From: Jean Fraser <JF@portlandmaine.gov <mailto:JF@portlandmaine.gov> >
Date: Jan 21, 2016 4:19 PM
Subject: Prelim review comments 31 Fore St
To: William Savage <wsavage@acorn-engineering.com <mailto:wsavage@acorn-engineering.com> >
Cc:

Please find below the preliminary comments, pending the receipt of additional information from your team as requested below. I do not yet have written review comments and have not been able to speak to the City Arborist regarding the street trees and landscaping, so the following comments are not comprehensive - but I am sending them now as they relate to fundamental aspects that may require some redesign.

At this stage I am not sure that the proposal meets the R6 ordinance requirements, so the timing of the PB workshop will depend on whether we can confirm compliance with the basic zoning standards as set out in 14- 139, especially regarding the height and setbacks above 35 feet. The application asserts that requirements have been met but does not include information for us to document that is the case.

SETBACK ANALYSIS & PROPOSED FOOTPRINT		
Ref Dwg:	Scale: 1/16" = 1'-0"	Issued :
		Revised :

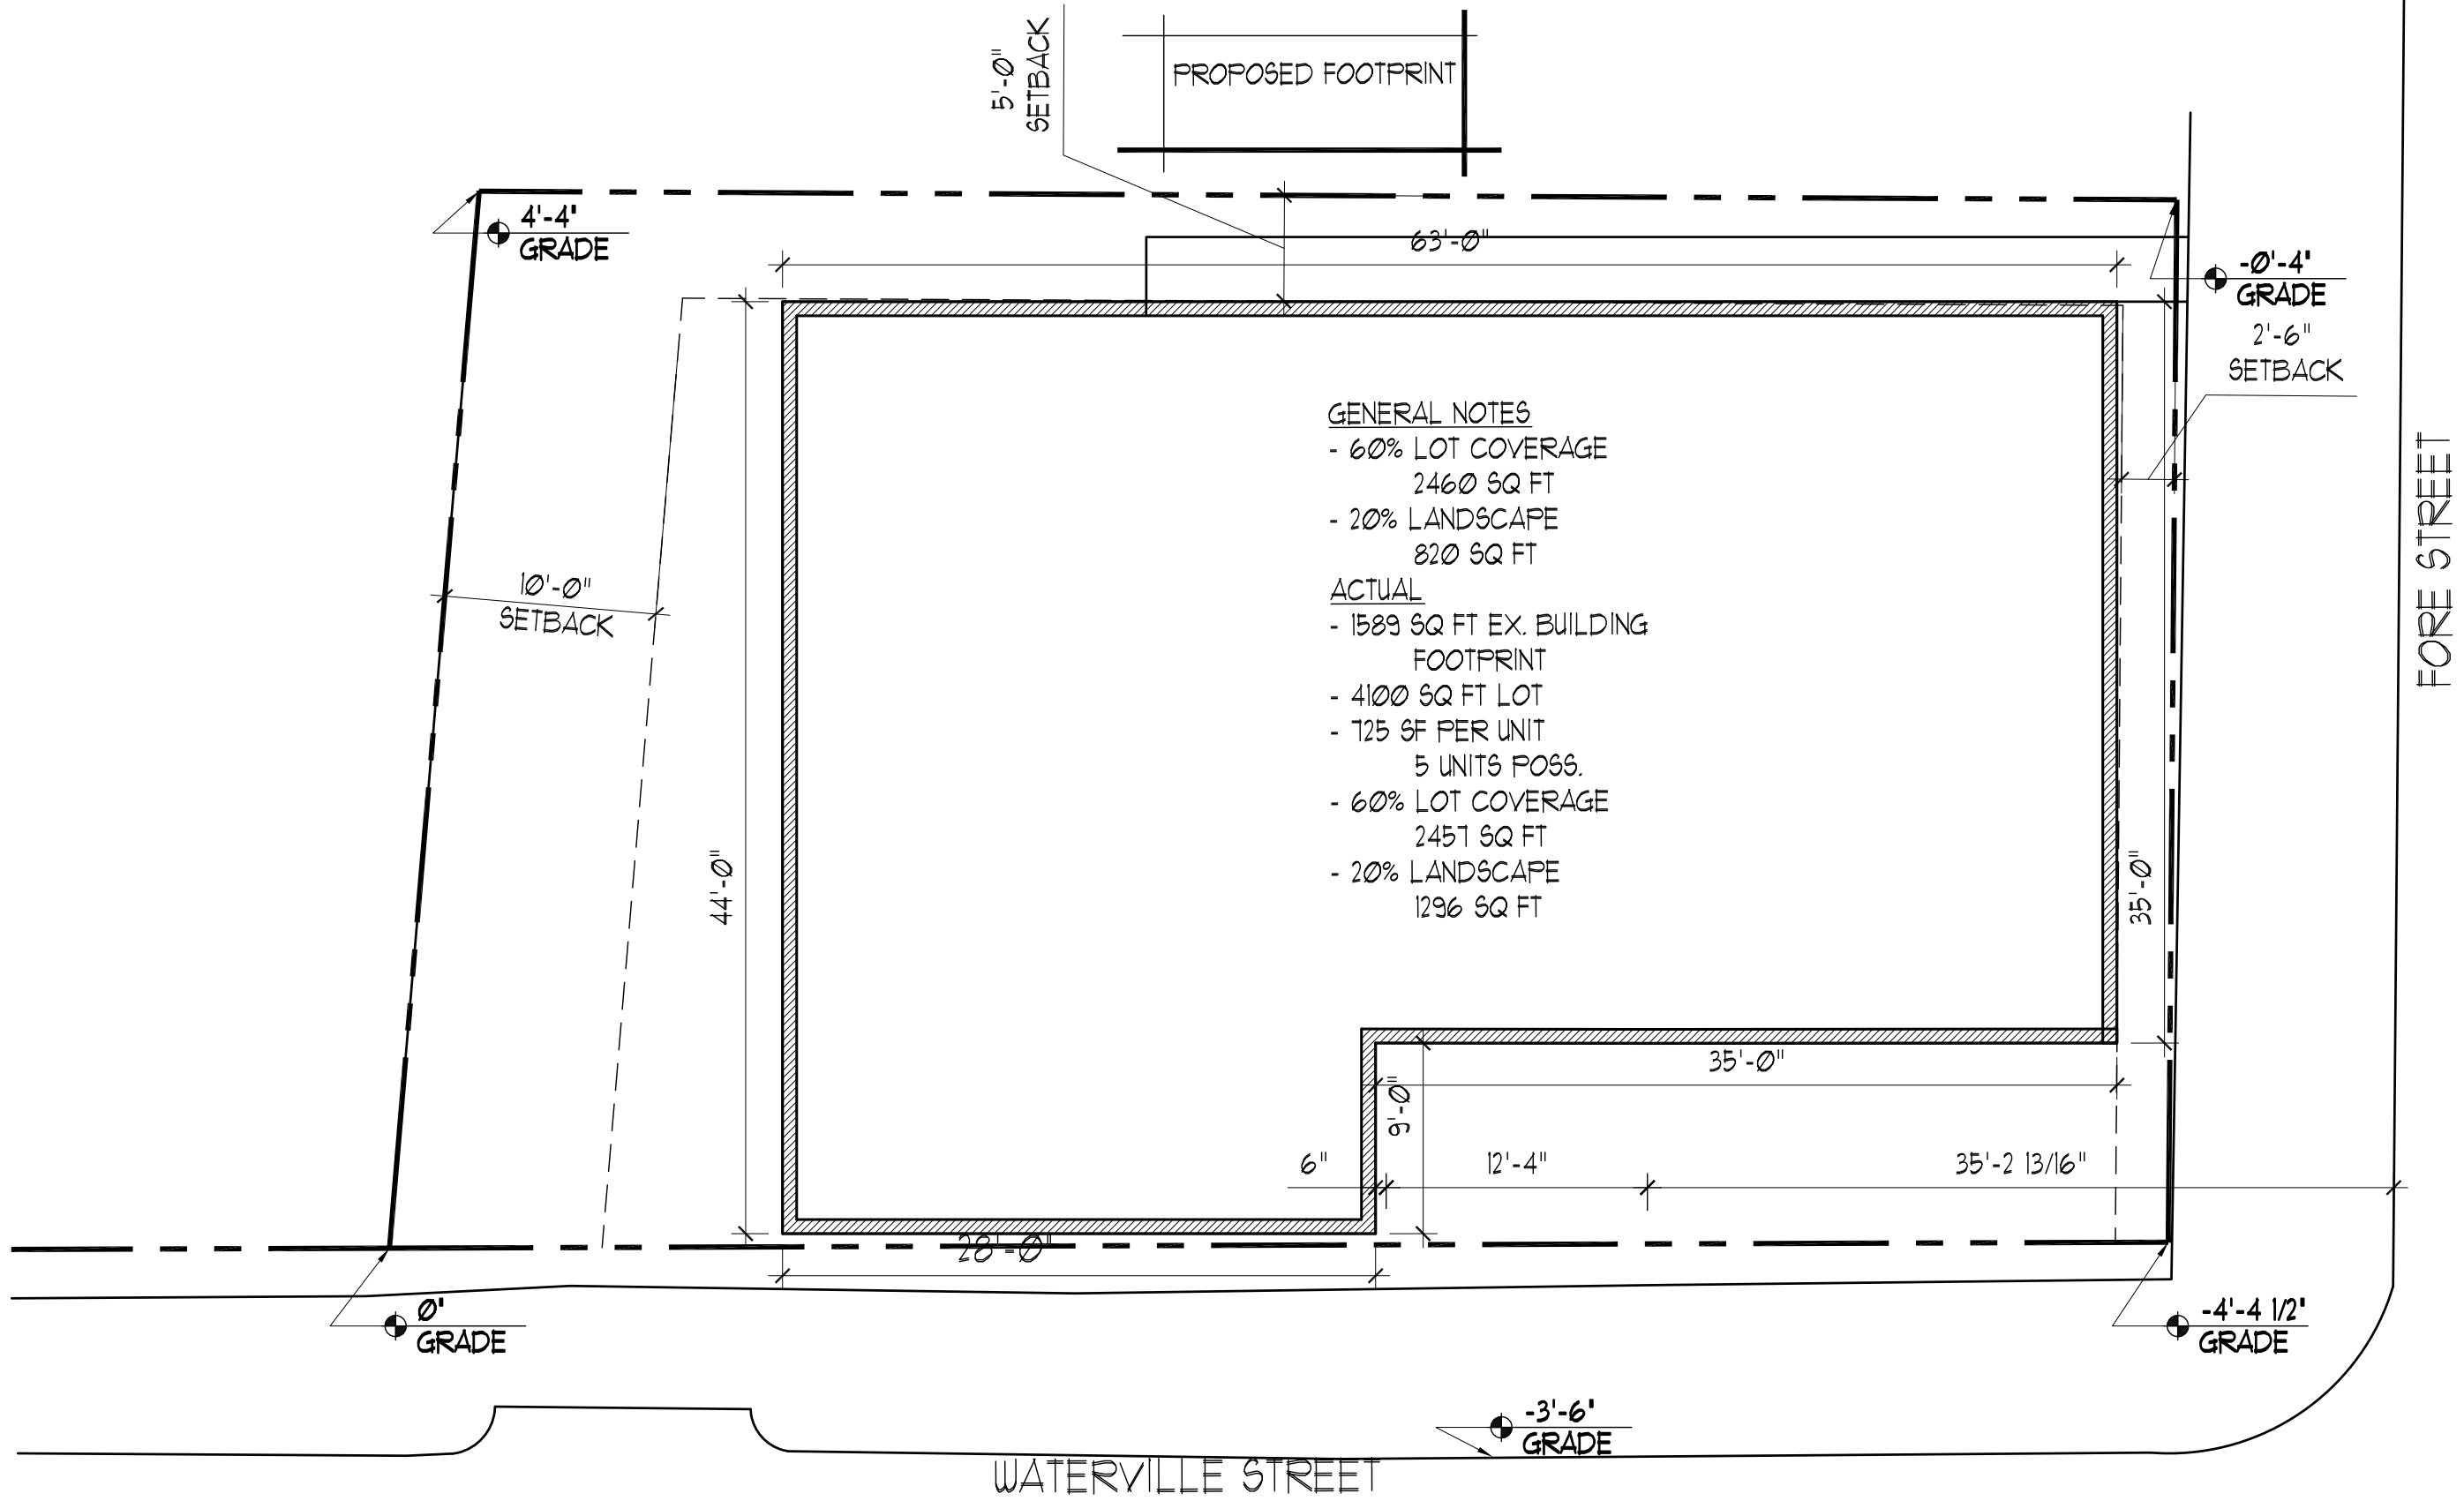
- * Minimum Front Yard Setback for Principal and Accessory Structures: 5 ft, or the average depths of adjacent front yards. (need to state how this has been met (based on the advice given to you by the Zoning Administrator)

- * Structure Stepbacks: Portions of a structure above 35 ft shall be no closer than 10 ft from the side property line and no closer than 15 feet from the rear property line when such property line abuts a residential zone. Does not apply to side yards on side streets. (show setback lines and show that building above 35 ft in height meets these setbacks- appears not to on the uphill side and maybe also at the rear. The standard relates to the scale and bulk of the building, so it would not matter what's inside that part of the building. All parts of the building need to meet these applicable setback line(s), which should be shown on the plan. Since there is another abutting building very near we would expect the setbacks to be met.)

Please see attached R-6 Infill design Analysis which I believe will address many of the concerns including Setback and Height Restrictions you noted in your email below. Also note that we have had a prior meeting with Anne Machado from Portland Zoning as well as a Pre-app meeting where many of these issues were discussed. I think the Aesthetic issue that you are seeing is the Garage level which we agree is lacking articulation and design appeal. The reason it looks the way it does is that we are working with the client on 4 or 5 different options for this level, playing with materials and fenestrations. The current rendering is showing a Ship lapped or tongue and grooved cladding with the intent of having some window openings as well as trim to match the materials and fenestrations above. Unfortunately we weren't able to have this reflected on the renderings before we needed to submit the information you requested on Wednesday. I will forward you New renderings as soon as we have worked through all of the issues but please know that the Garage level final design will not look the way it currently does and will comply with the City of Portland's R-6 infill design standards. Please let me know if you need anything else to move forward towards the Planning Board Review and I will send new drawings as they are completed. Thank You and feel free to call me if you have any other issues that you'd like to discuss. Thanks

Drawing file: Jan 26 / 31 FORE ST AVERAGE GRADES.pdf

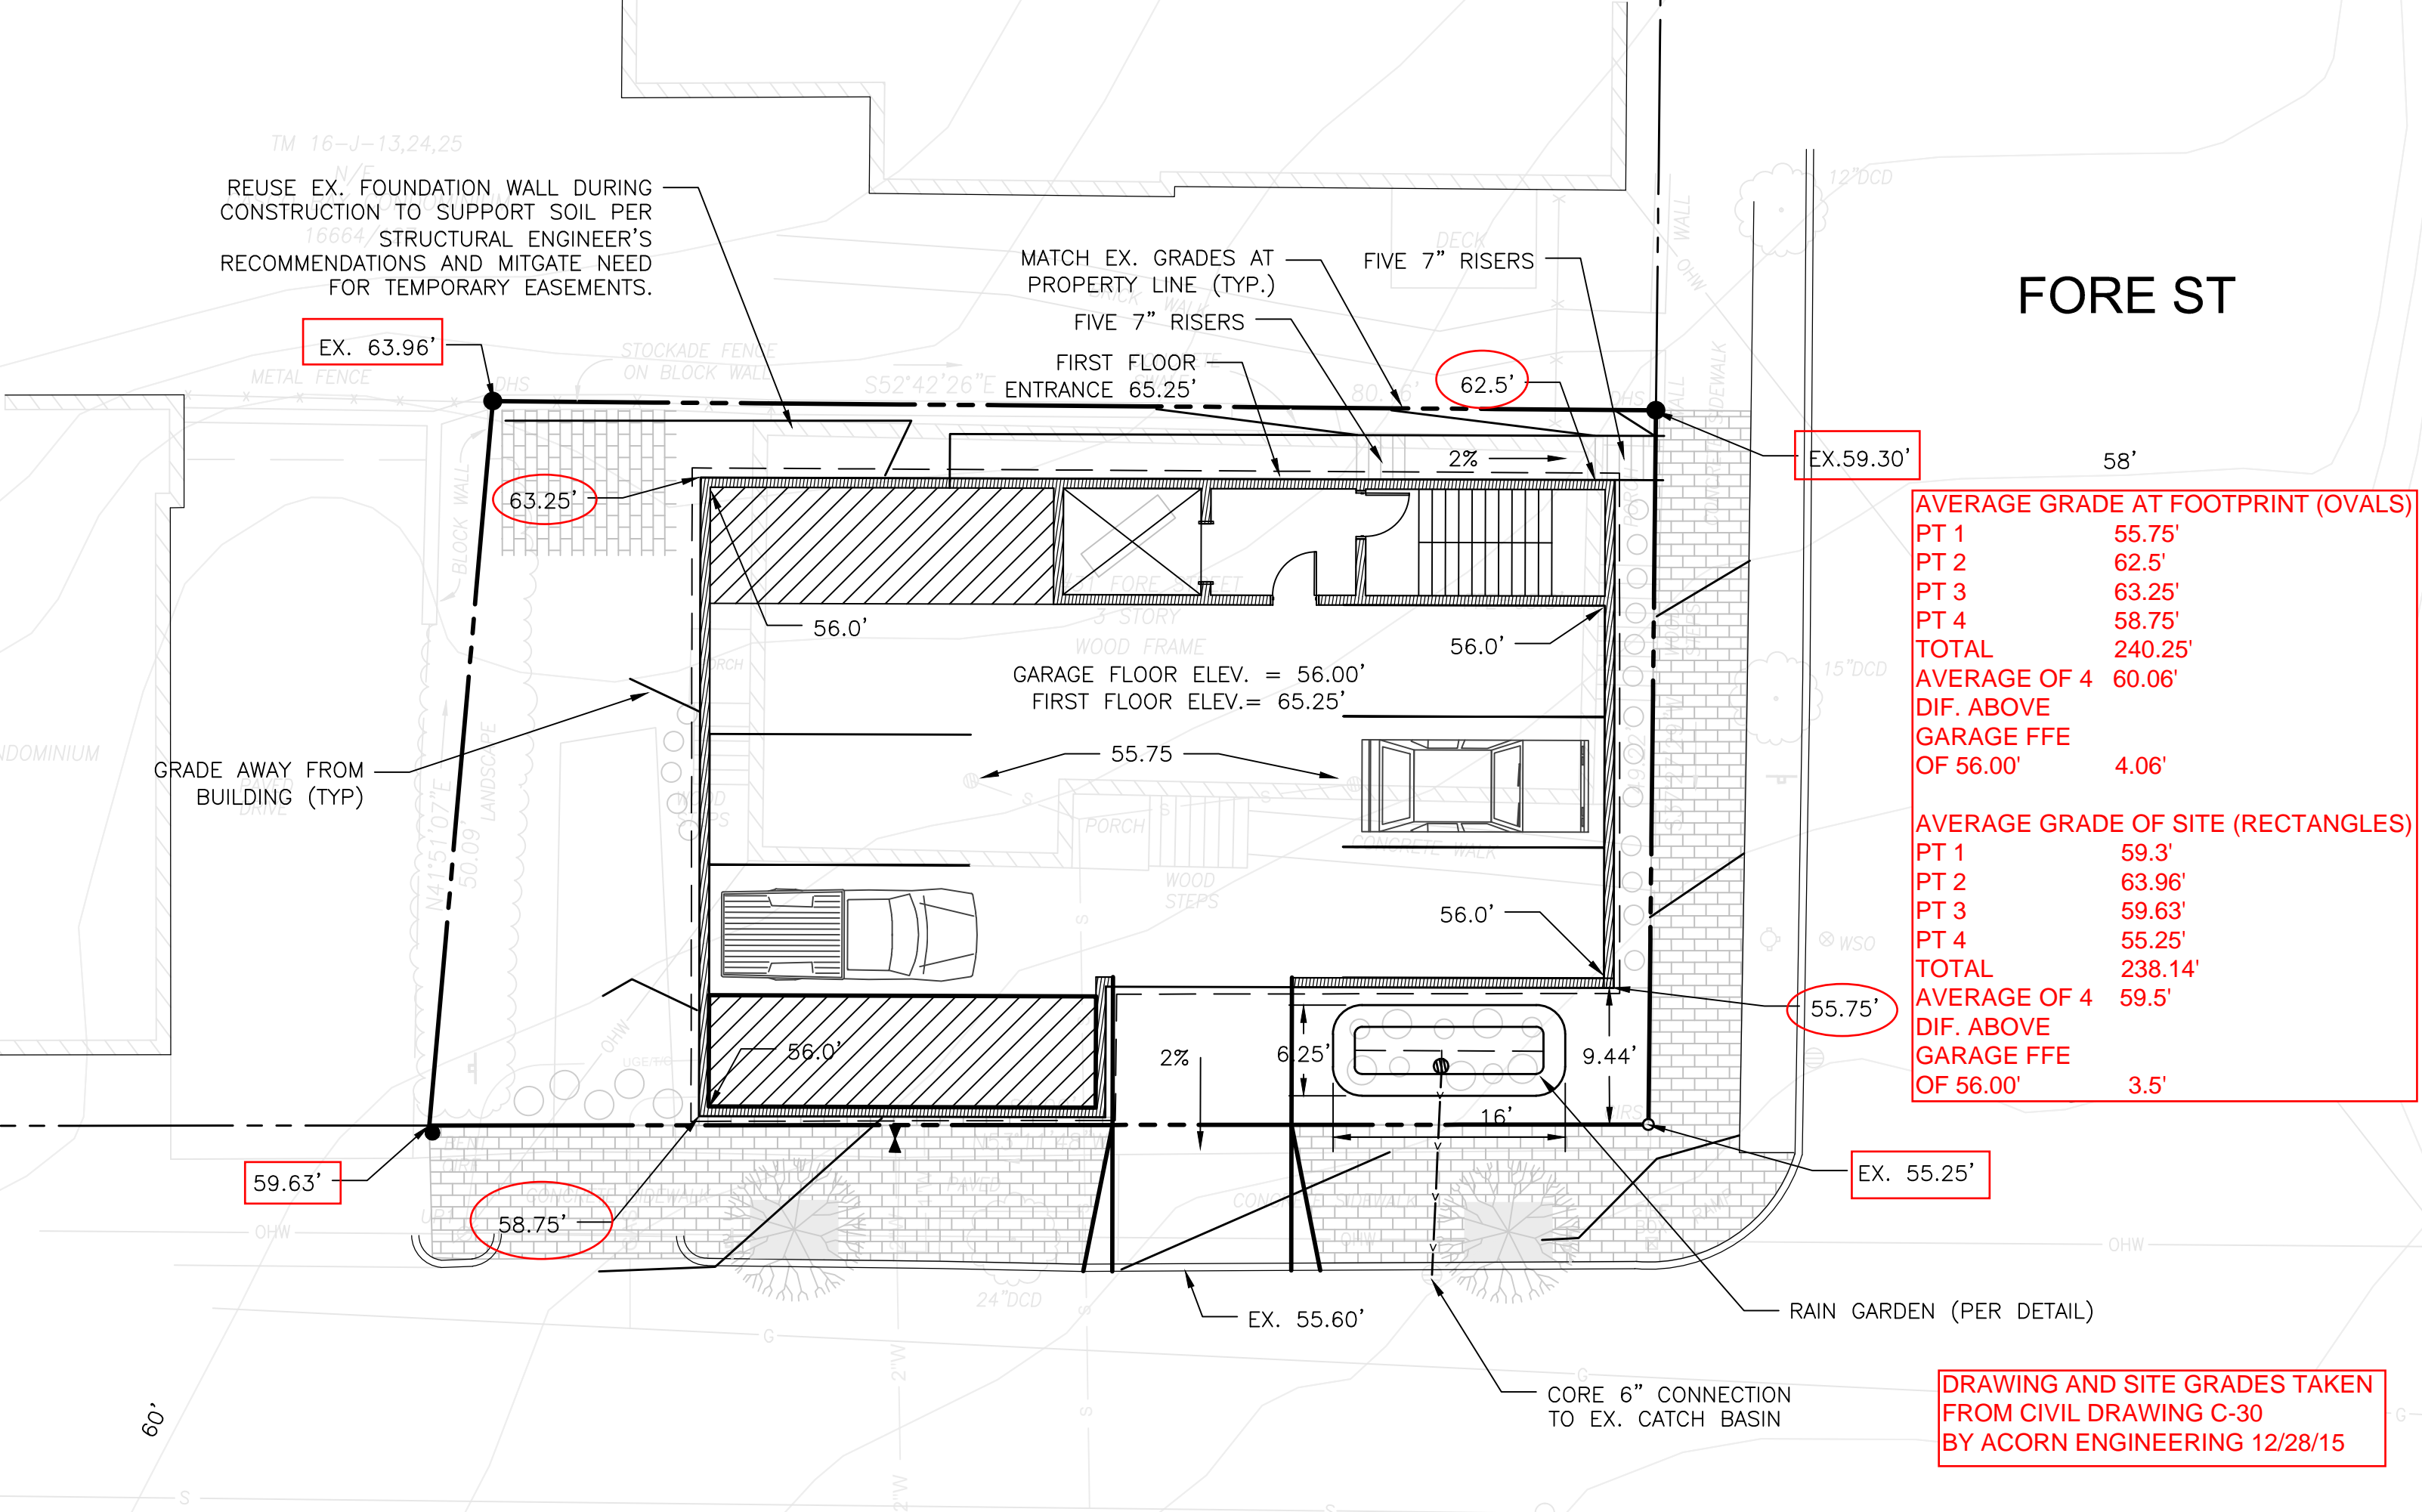
- * Height: this would be calculated by first establishing the average proposed grade at the base of the foundation/structural wall using information from the grading plan. At the moment that plan seems to indicate (using the 4 corner numbers) an average grade of around 60', while the roof is shown at 137' 4" on the elevation, giving an average height of 77'. It would be helpful if the plans and the elevation put dimensions in the same way (either as feet and inches, or as decimal feet). Also the proposed grades shown around the base of the building on the elevations are not realistic and do not match the plans - also the south west corner is shown as 2 different proposed grades on the elevations.

* Grading information and contours are needed on the grading plan and need to be consistent as between plans/elevations;
